Appeal Decision

Appeal Ref: APP/Z4718/W/25/3369783

43 Daisy Hill, Dewsbury WF13 1LF

- The appeal is made under section 78 of the Town and Country Planning Act 1990 (as amended) against a refusal to grant planning permission.
 - The appeal is made by Mr Masum Karolia against the decision of Kirklees Metropolitan Council.
 - The application Ref is 2025/62/90364/E.
 - The development is the proposed change of use of retail space to one bed flat.
-

Issue Purpose : Full Application		
Project	Proposed change of use of ground floor to one bedroom flat	Date 28-01-2025
		Scale 1:100 @ A3
Address	43 Daisy Hill, Dewsbury, WF13 1LH	Ex and pr Elevations
		D.N. 2025 - 43DH - 03

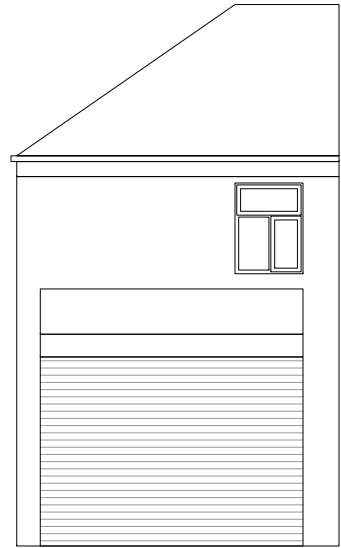
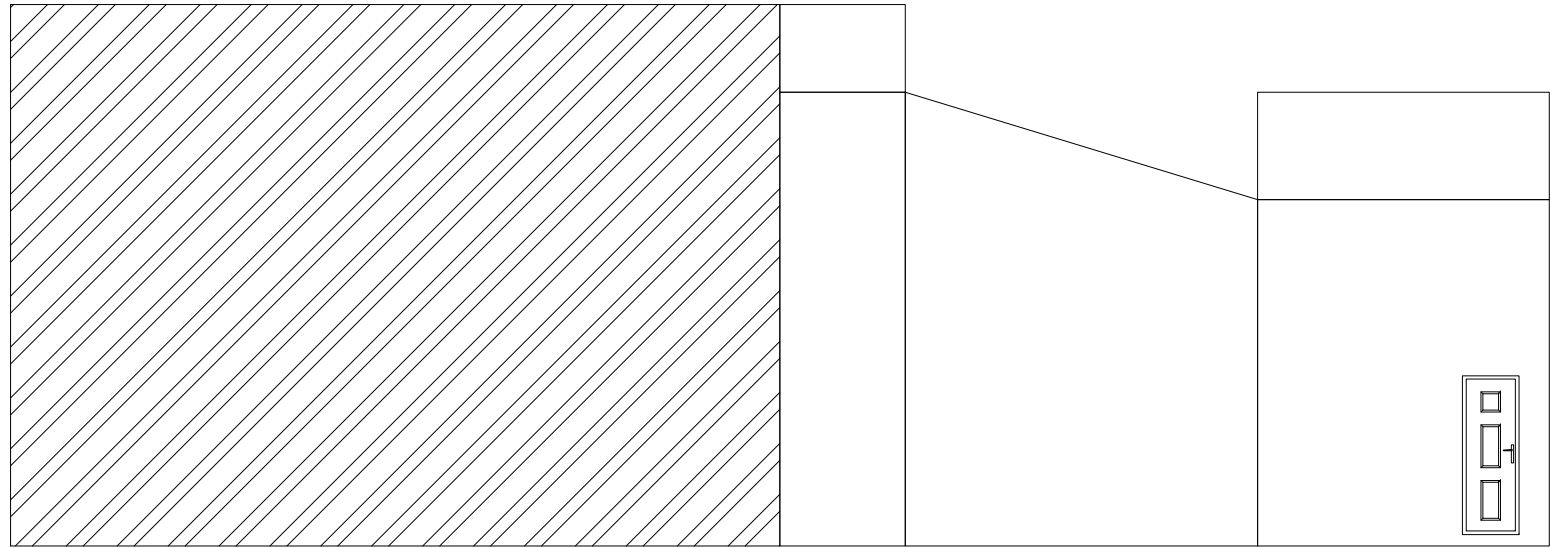
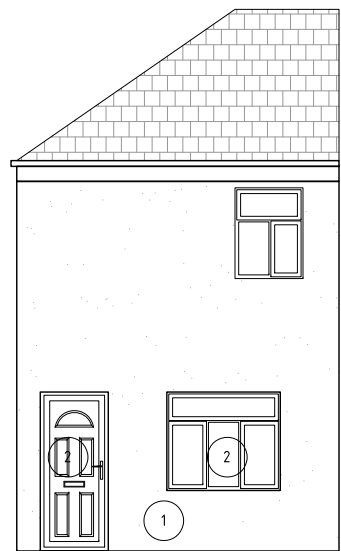
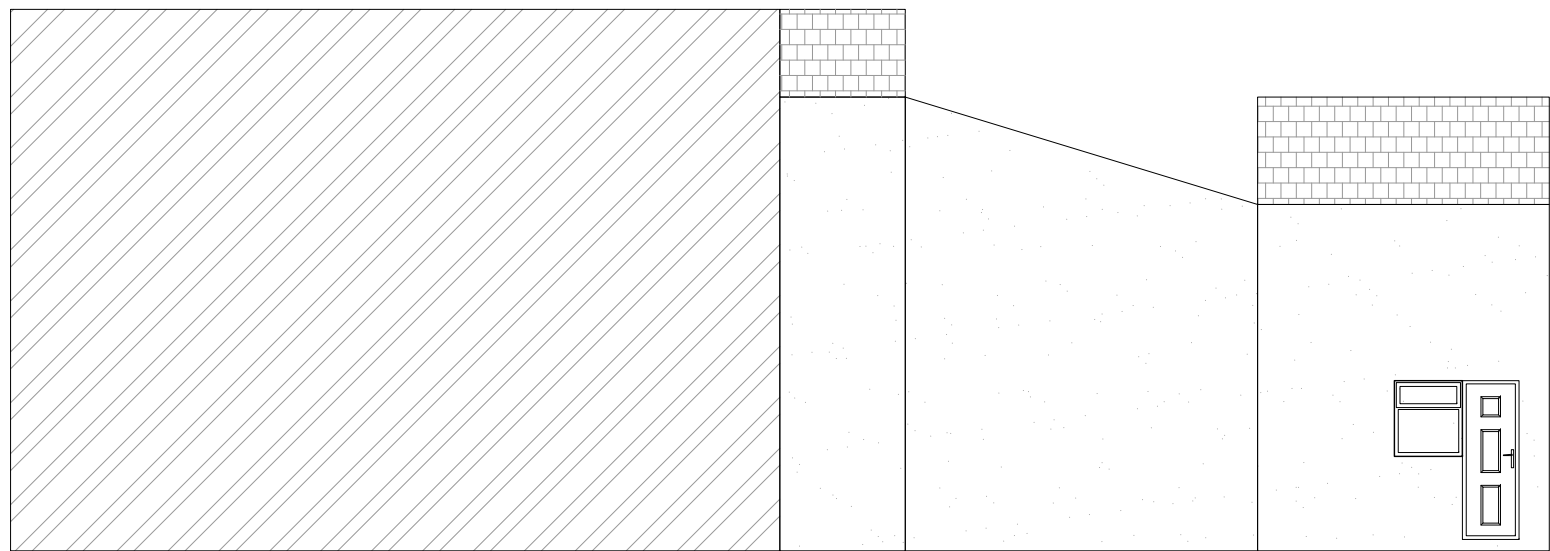
12. The proposed one-bedroom flat would have a door and window facing onto Daisy Hill serving its shared living and bedroom space, it would also have a window to the rear side serving a proposed kitchen that would look directly towards the rear of the adjoining property in an enclosed area. On the opposite side of the road is 34-36 Daisy Hill, a two-storey property containing a shop and glazed opening at ground floor level, it is said to be some 8-8.5 metres at its closest to the appeal property.

13. Notwithstanding the gap between it and no. 34-36, the presence of the building opposite would significantly impede the outlook from the proposed flat's only outward looking window on its front side, giving a very poor and harmful outlook for future occupiers, mainly restricted to views of surrounding buildings in an enclosed setting. Given its ground floor location within the town centre, it is also accepted that future occupiers may choose to use blinds or other privacy measures, which would likely add to the poor outlook from its shared living space.

14. The proposed new window facing onto Daisy Hill would be large, but no daylight assessment has been provided to demonstrate future occupiers would receive adequate light to the proposed accommodation. Due to the layout of the main shared room said to be some 11 metres in depth, the bedspace would be farthest from the window and would likely receive very little natural light, and as a result there would be harmful effects for the living conditions of its future occupiers. Whilst it would have a window serving a kitchen to the rear, this would also be towards the rear sides of other buildings and would not off-set the poor level of light and outlook for the main living area. Nor would its size being in excess of the minimum size required by the Technical Housing Standards – Nationally Described Space Standard (March 2015) fully justify its poor level of light and outlook for future occupiers. Whilst the appellant has indicated that they are willing to amend the layout, no amendments have been provided.
